Our ref: HA/2020/122048/01-L01
Your ref: BN/15/20/PL
Date: 05 March 2020

ERECTION OF 1 NO.END OF TERRACE TWO STOREY 2-BEDROOM DWELLING.

LAND ADJACENT TO 49 WARREN WAY BARNHAM PO22 0JX

Environment Agency position

BLOCK PLAN - SCALE 1:200

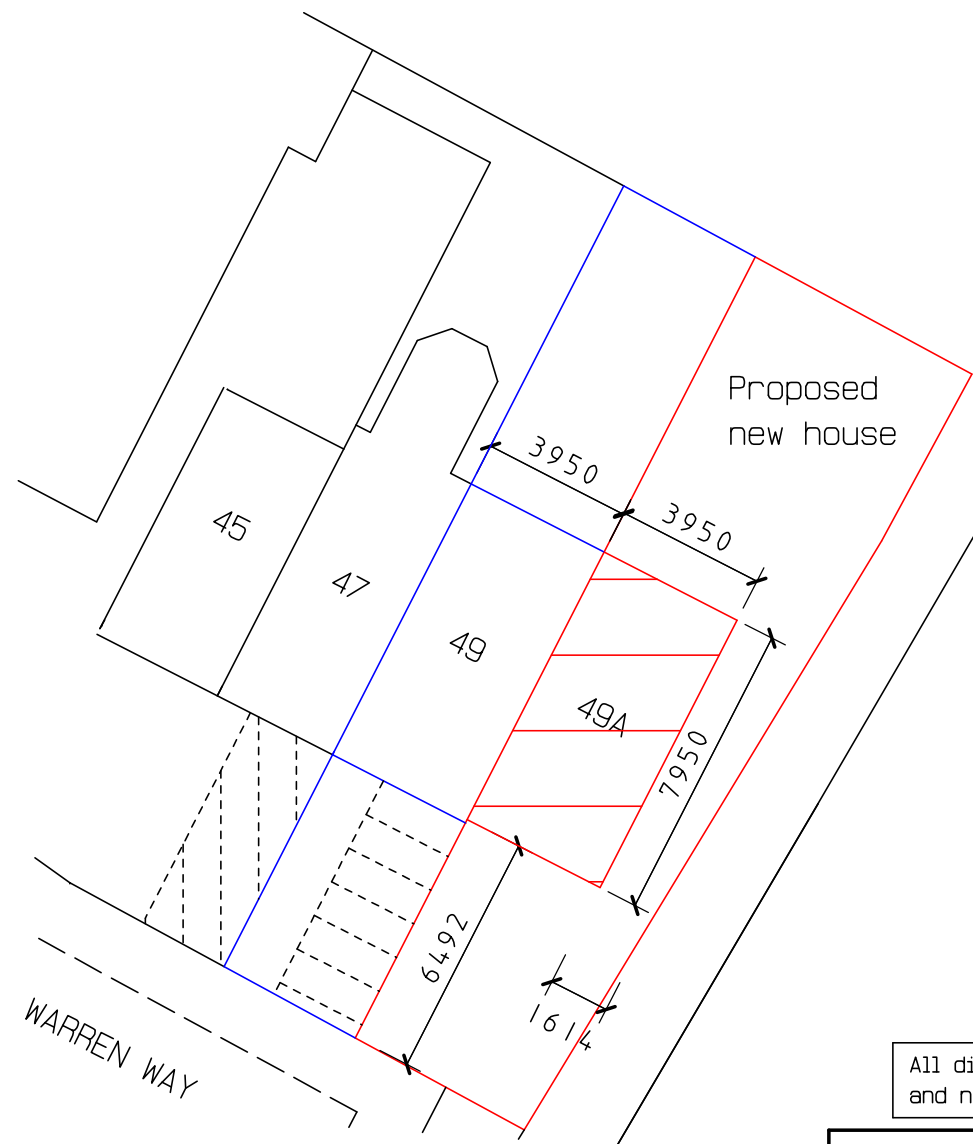
The boundary of the proposed dwelling will have a distance of 1.6m from a main river (Barnham Rife). Previous objections for the two storey extension were due to uncertainties of a FRAP being issued as we had insufficient details of foundations, therefore raising concerns on the stability of the bank. However, the applicant previously submitted further details relating to building foundations, which helped us in advising what we would need at the FRAP application stage.

The boundary of the proposed extension will have a distance of 1.6m from a main river (Barnham Rife) with previous objections relating to uncertainties of a Flood Risk Activity Permit (FRAP) being issued. This raised concerns relating to the stability of the bank due to insufficient details of foundations under the proposed extension being supplied.

- Accurate measurements of the foundation piling that show that piling shall reach a lower level than the river bed. We must be satisfied with the bank stability and that the extension will be adequately supported should undercutting of the bank occur
- Precise Drawings/ plans of where material will be stored to ensure no pollutants enter the river
- Photos of the site before works are carried out to ensure both the river and the bank have been returned to their previous state after works are completed

PROPOSED GROUND FLOOR PLAN

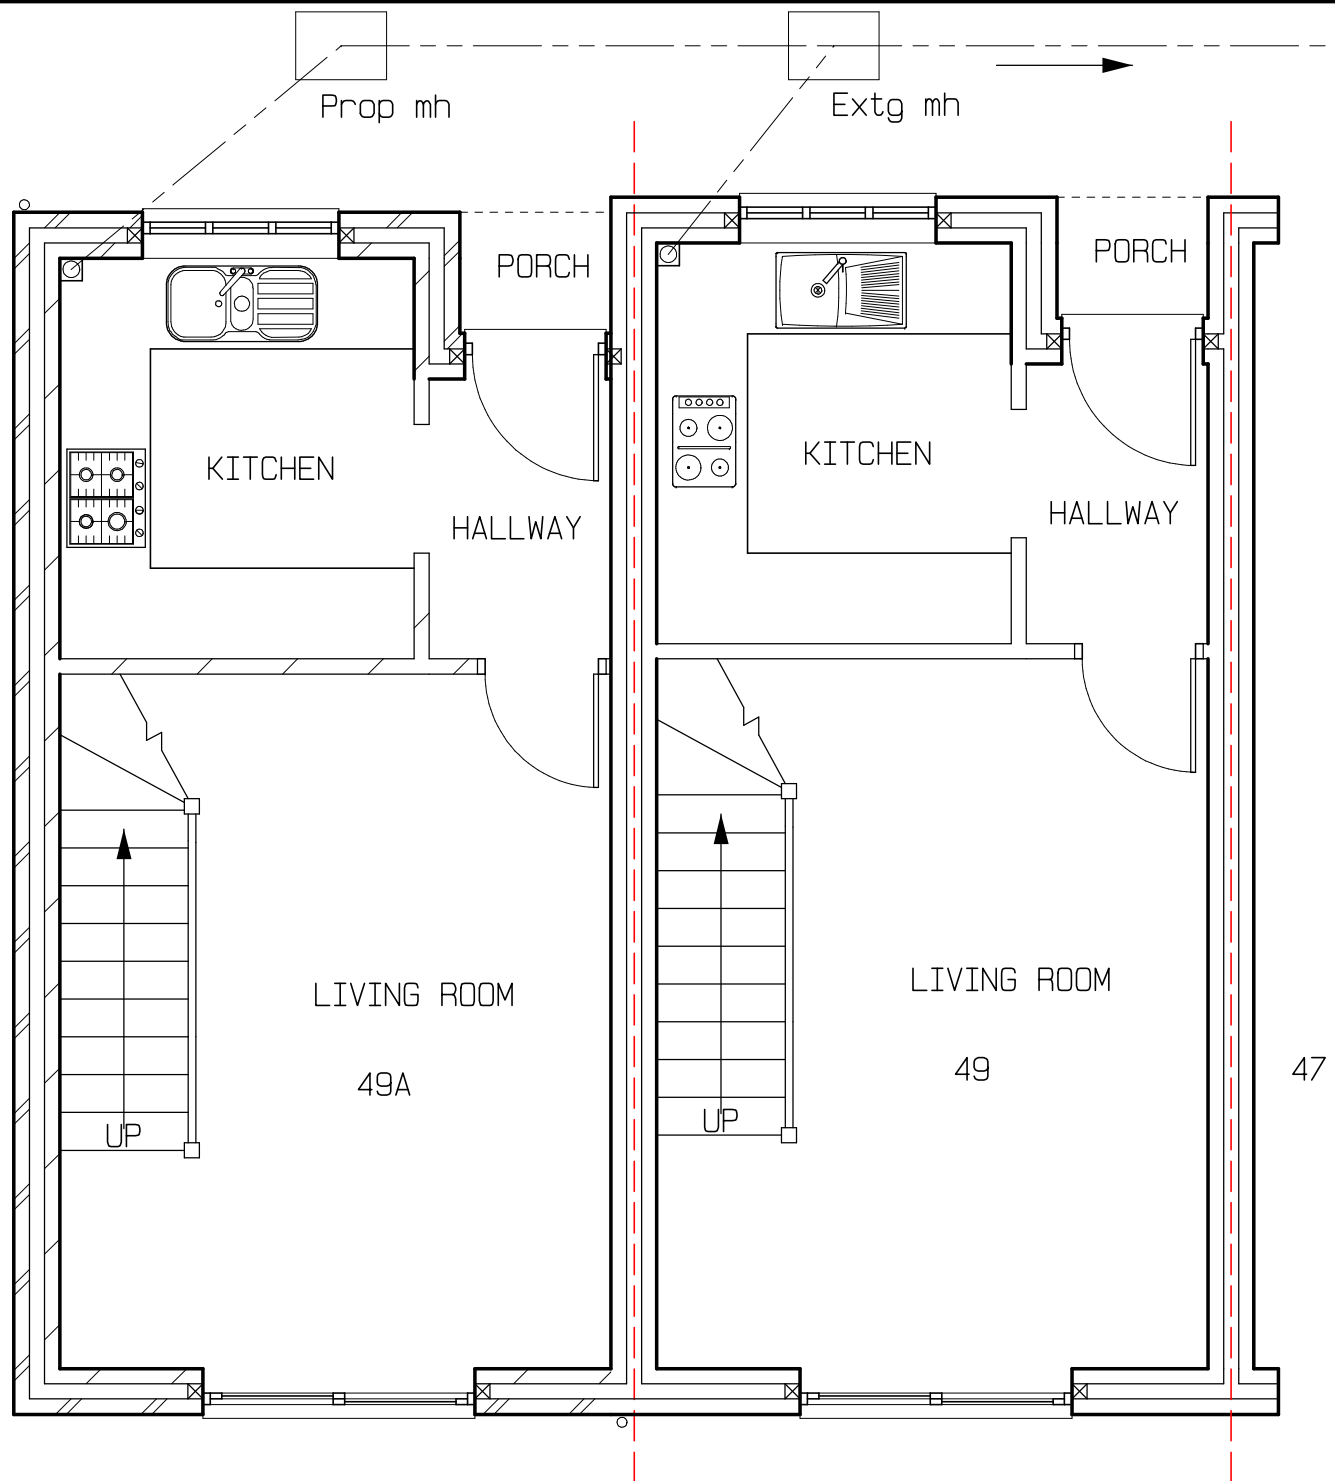
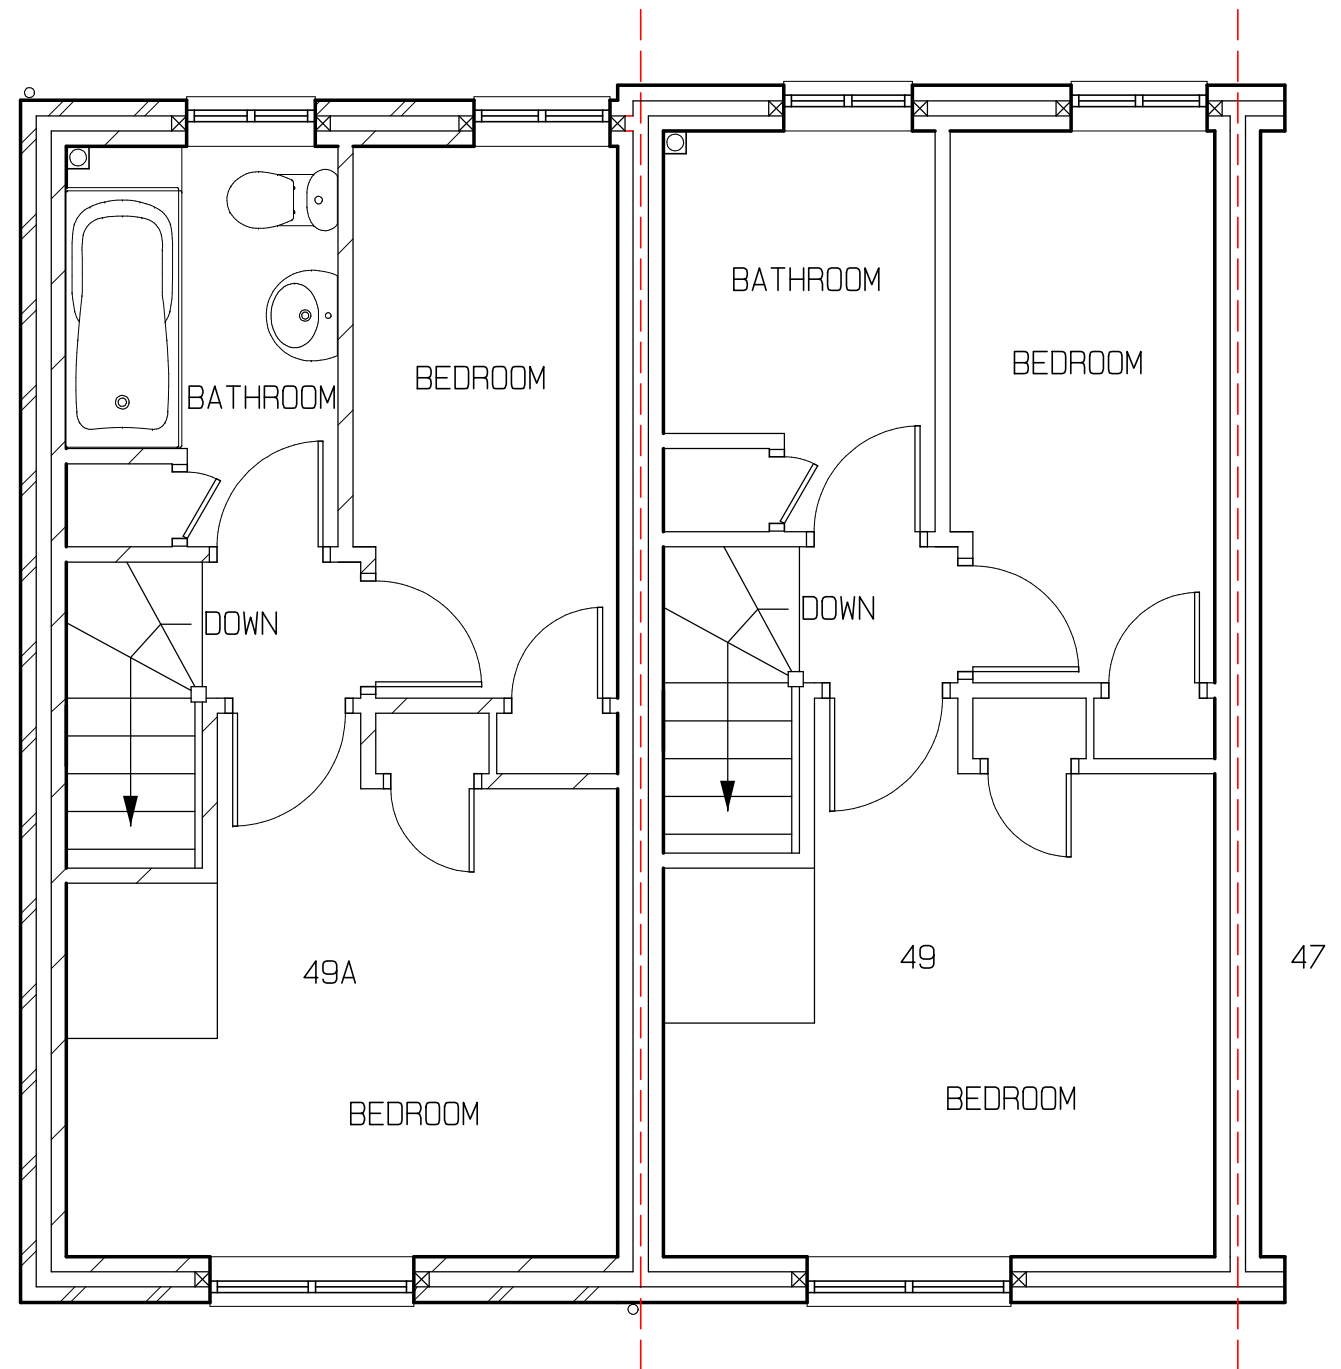
- Submit an up to date FRA to reflect the new application
- Clearly state finished floor levels for the dwelling

The proposed two storey dwelling falls within flood zone 3 (High Risk) of fluvial flooding. Plans show that there will be no sleeping accommodation on the ground floor therefore occupants will have safe refuge from flood risk on upper floor.

To overcome our objection, the applicant should submit a revised FRA which addresses the points highlighted above.
